Condition 3.

Hennock International Ltd

Drainage
Invert levels & pipe details

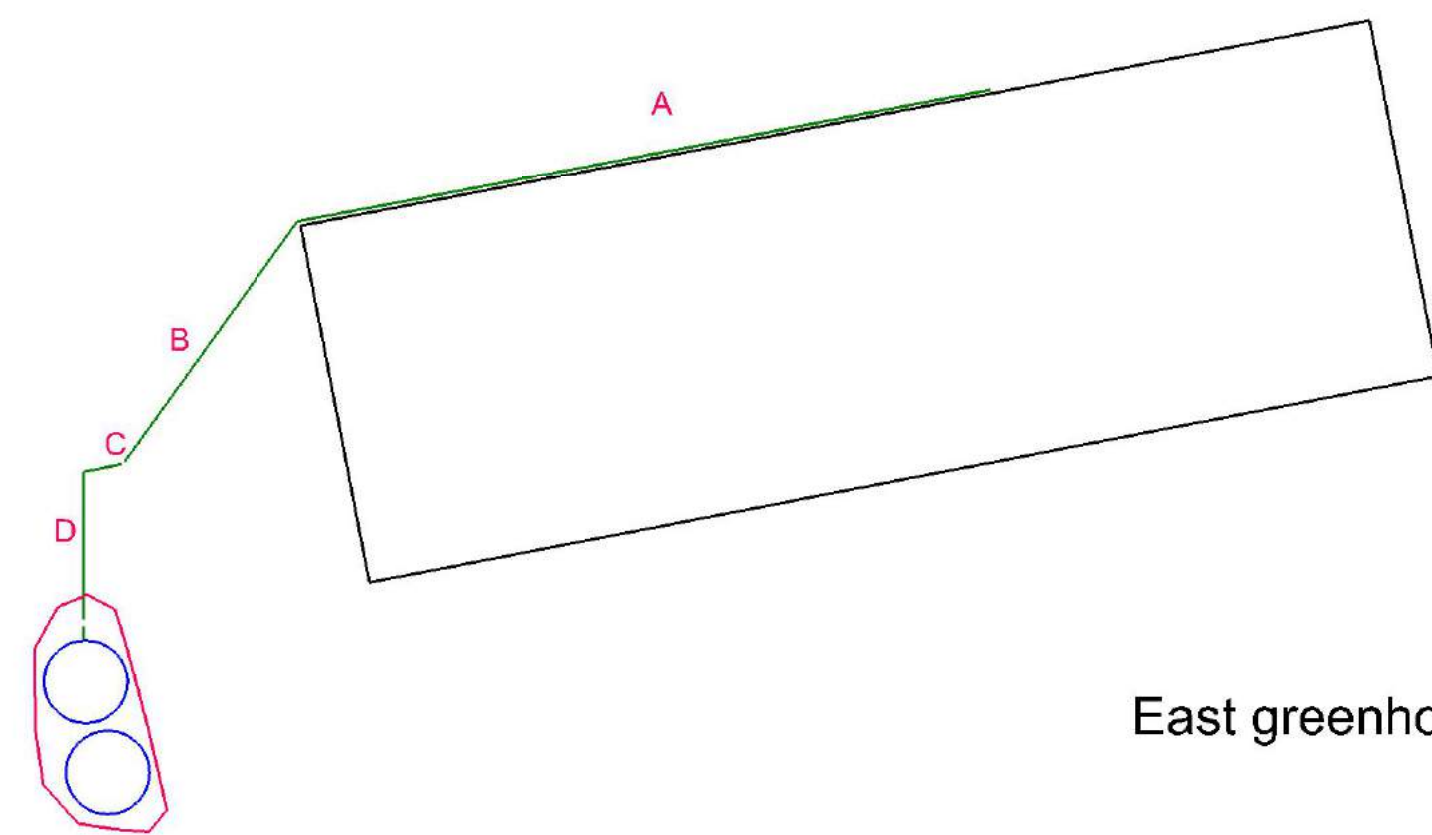
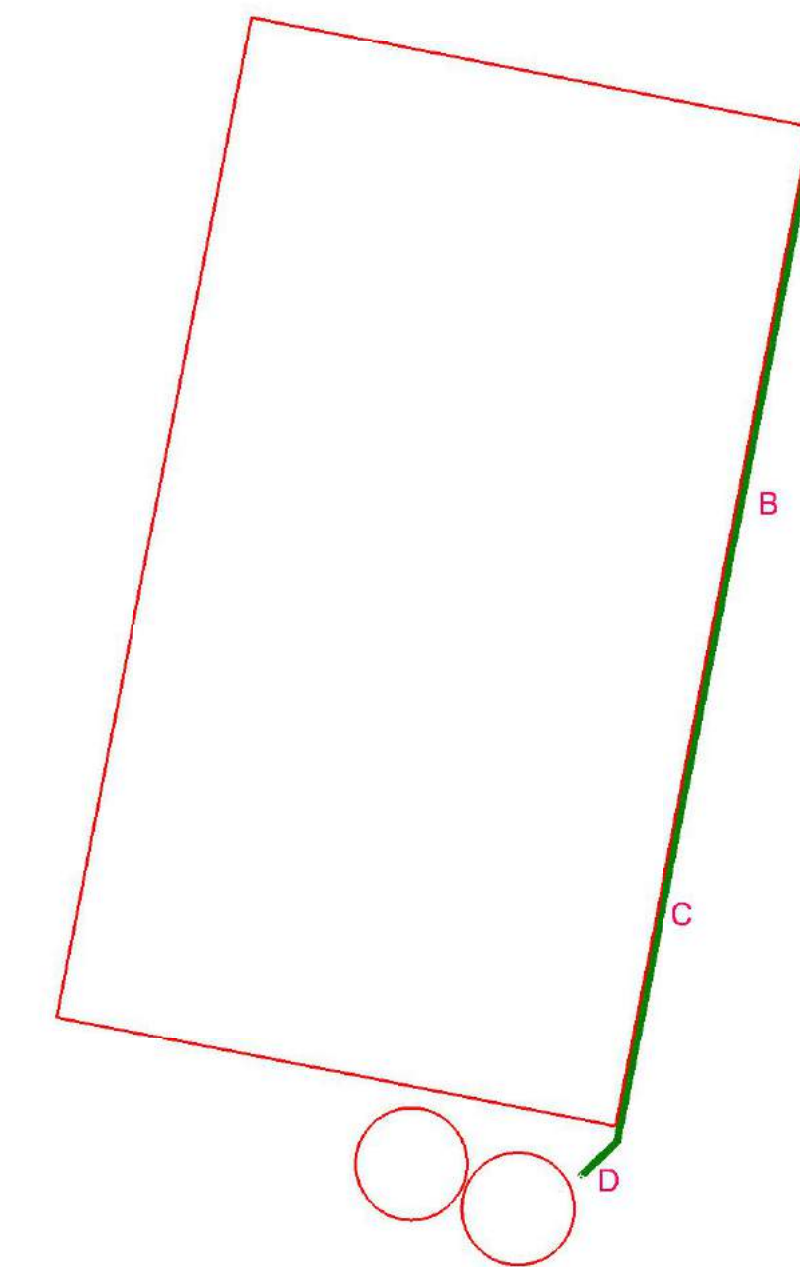
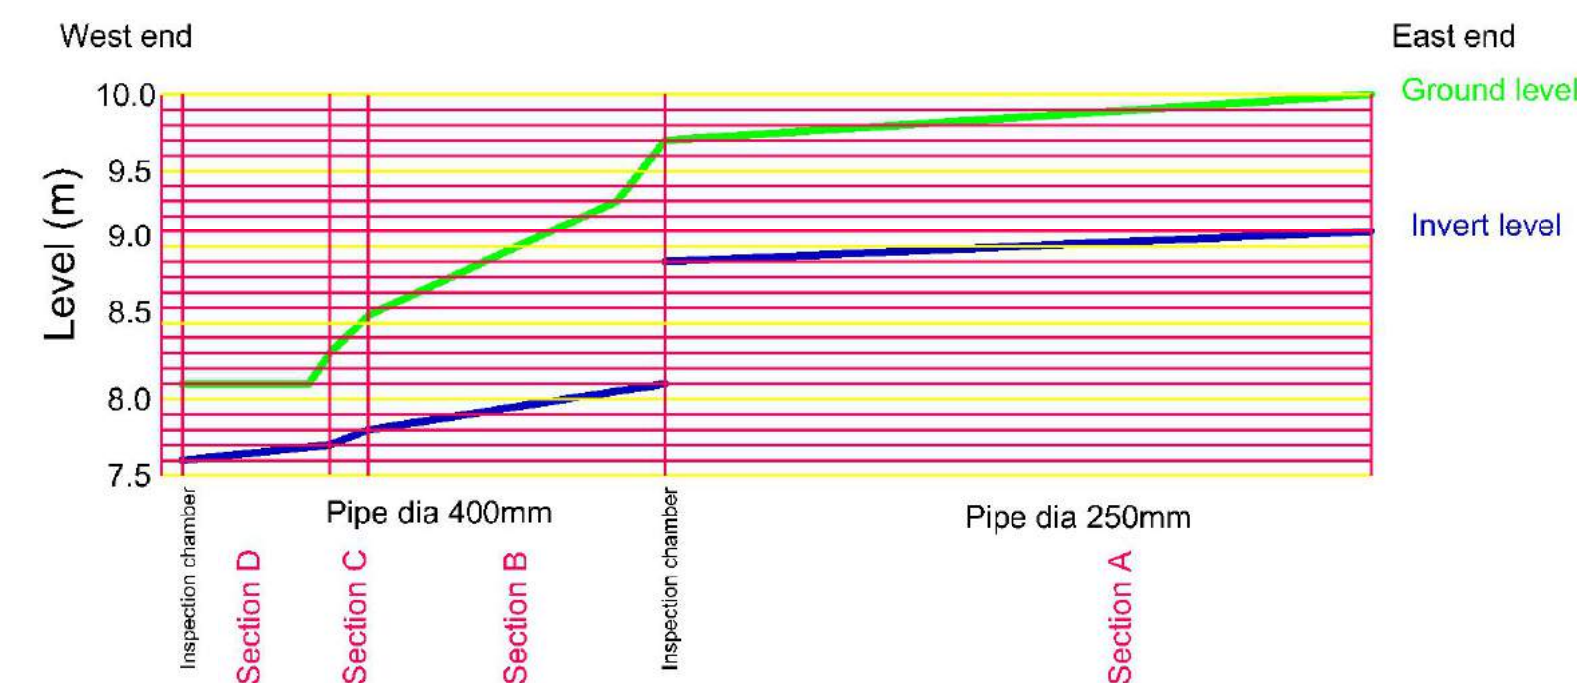
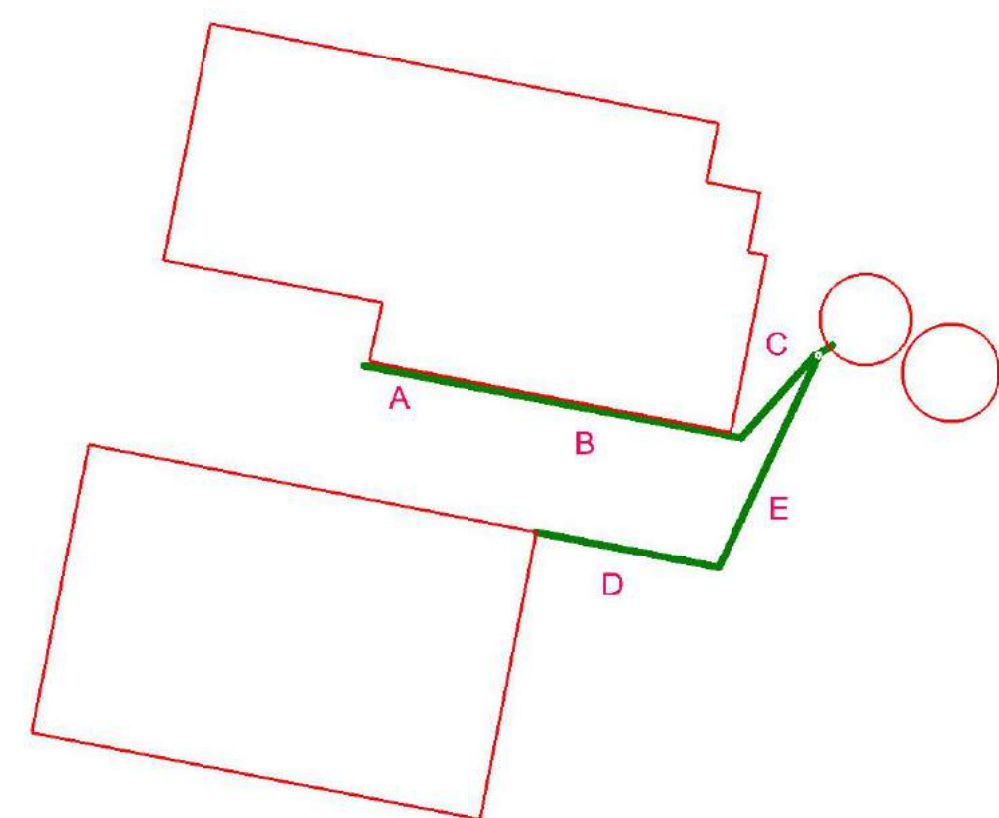
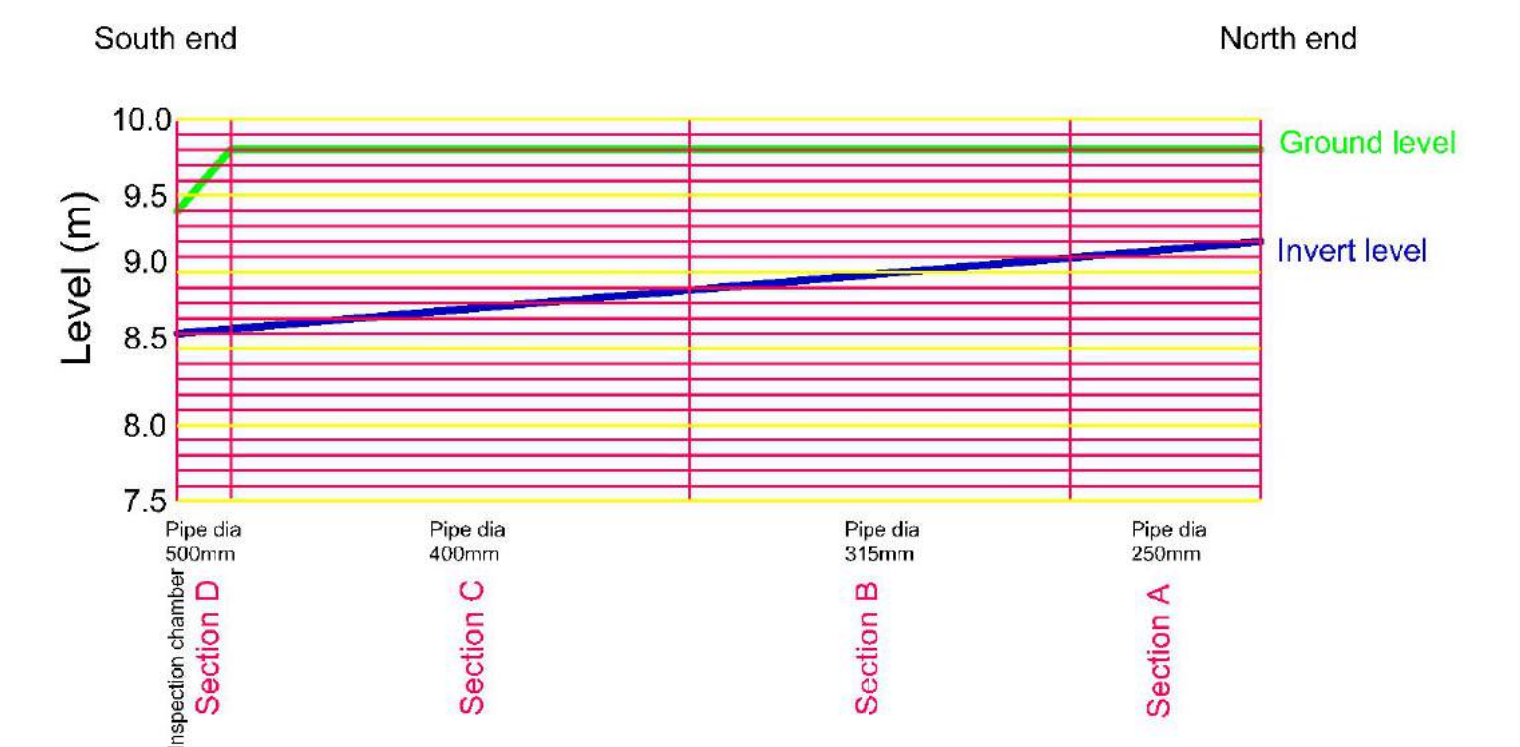
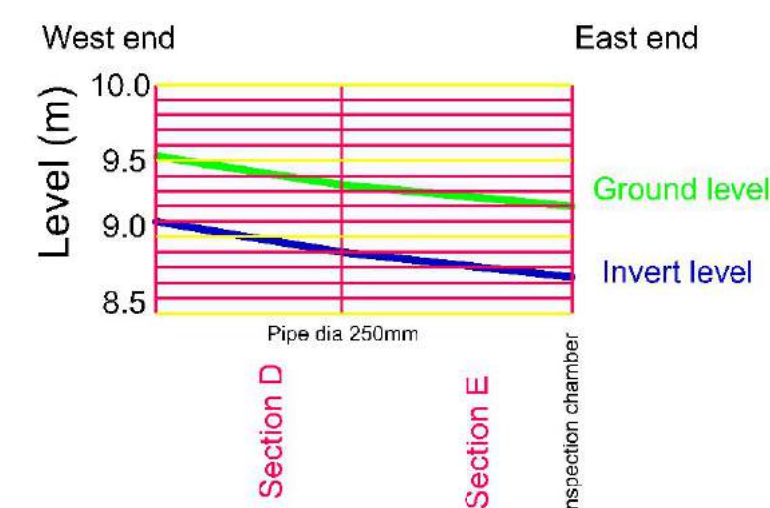
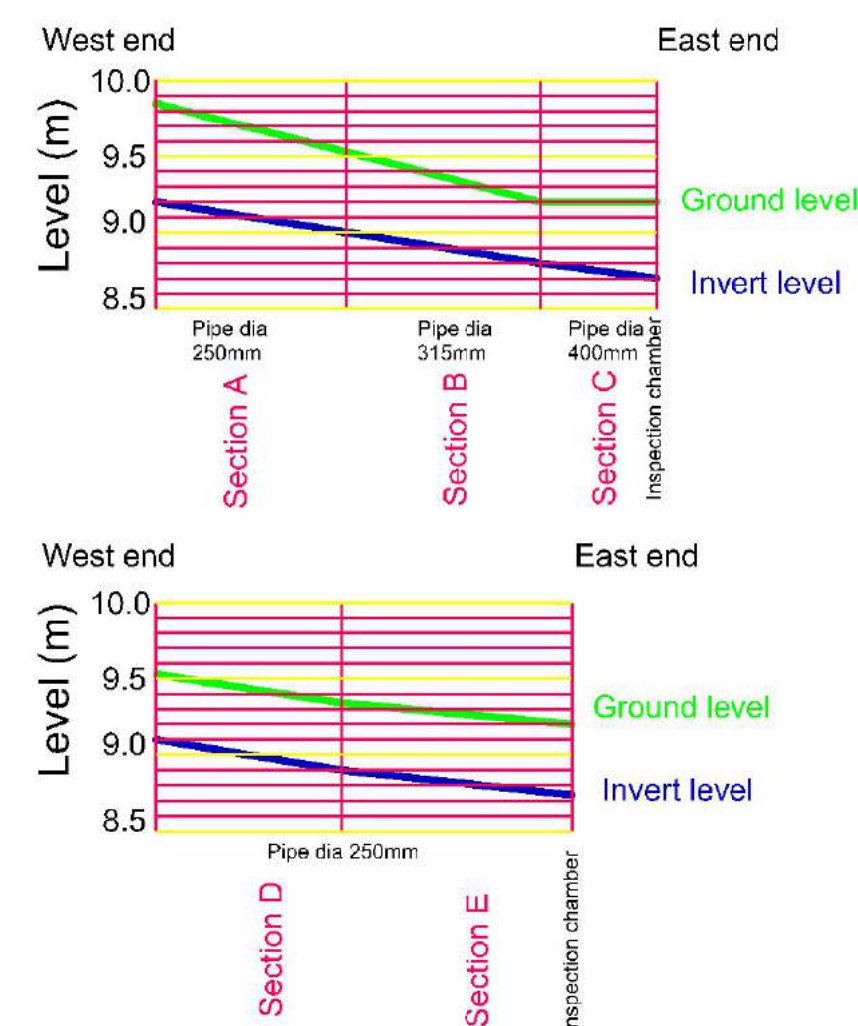
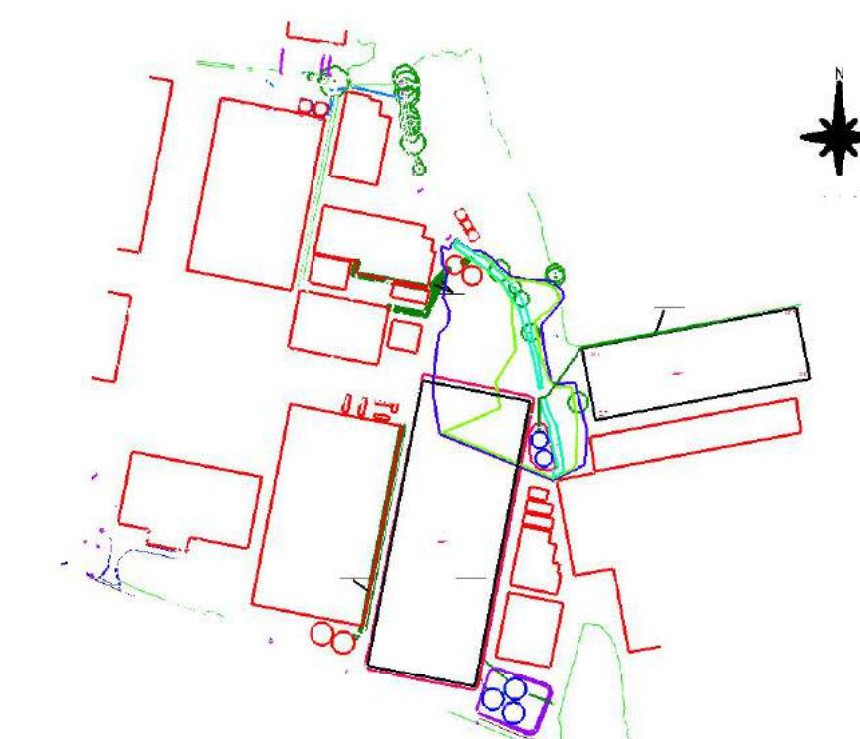
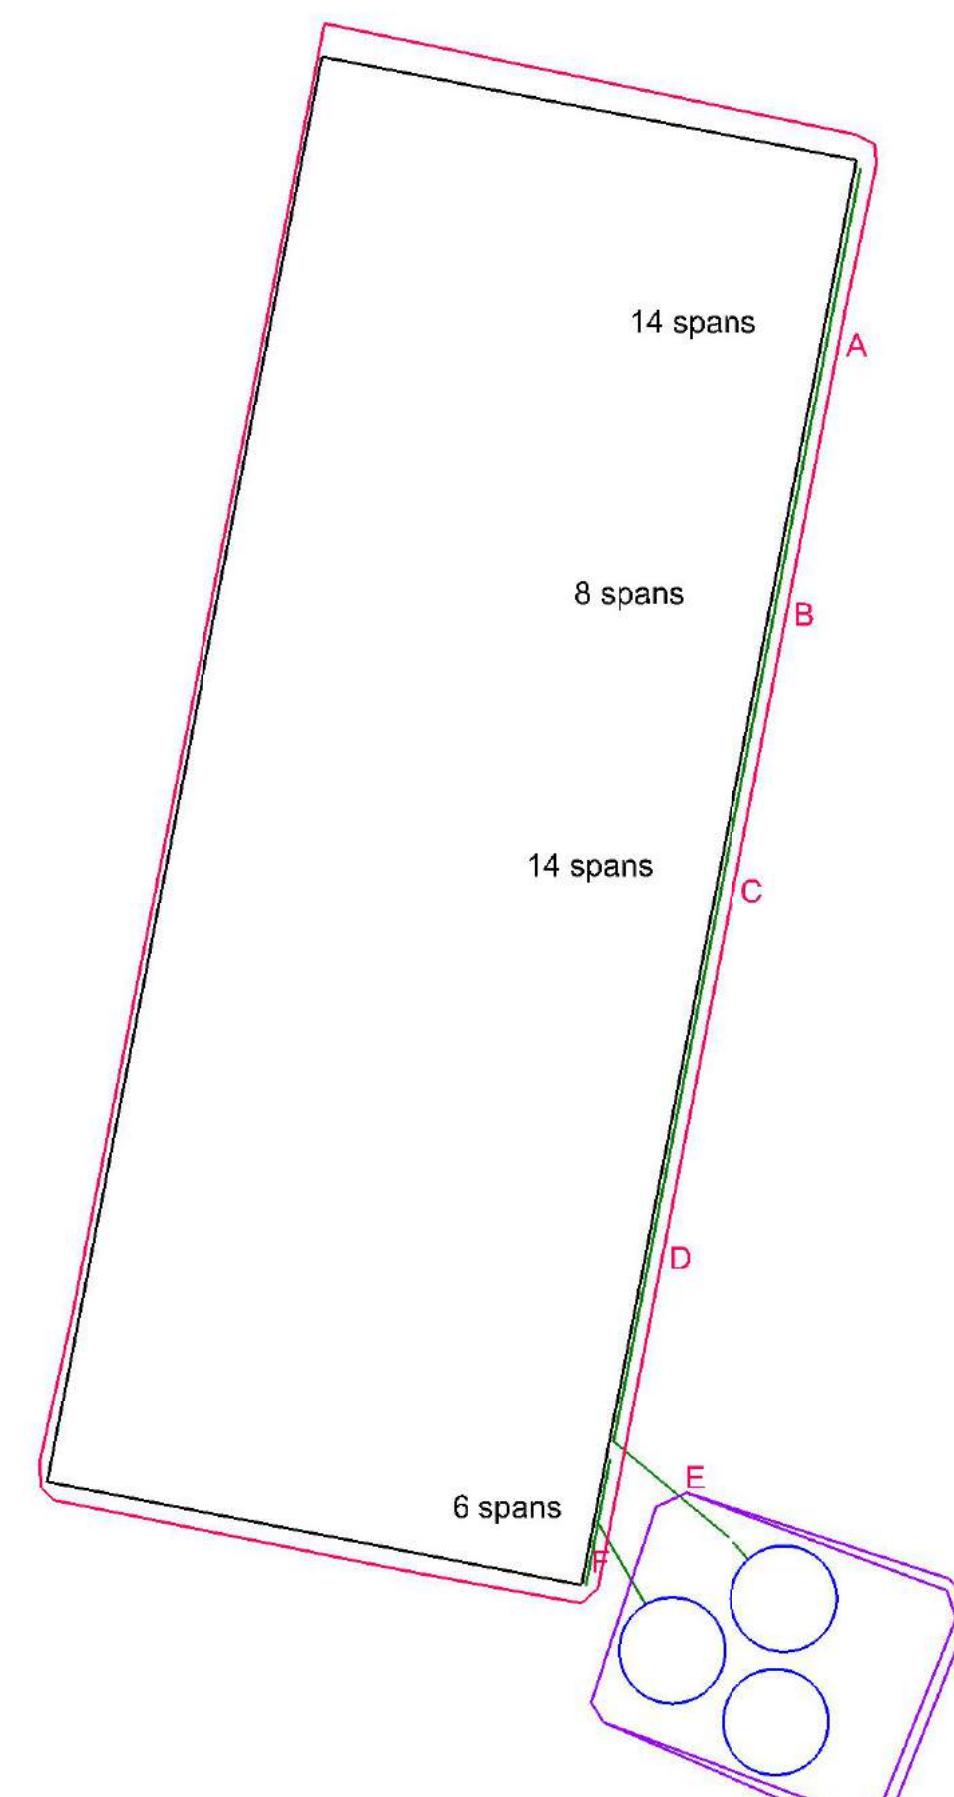
We presume that this relates to drawing "Invert levels", and have added additional items that hopefully render it clearer. If it refers to a different drawing please identify it for us.

This drawing has now been expanded out into 5 drawings for clarity.

Pipe and invert #1 - overall site layout naming the blocks as detailed in #2-5.

Pipe and invert #2 - North greenhouses (which are the only ones to feed the north outfall)

Pipe and invert #3 - South east greenhouses (which feed the south outfall)

Pipe and invert #4 - East greenhouses (which feed the south outfall)

Pipe and invert #5 - South west greenhouses (which feed the south outfall)

Diameter / depths etc. As far as we are aware all this information is submitted, but we have tried to make it clearer and split drawings, add text etc. to assist in this. This is all contained on the "Pipe and invert" drawings.
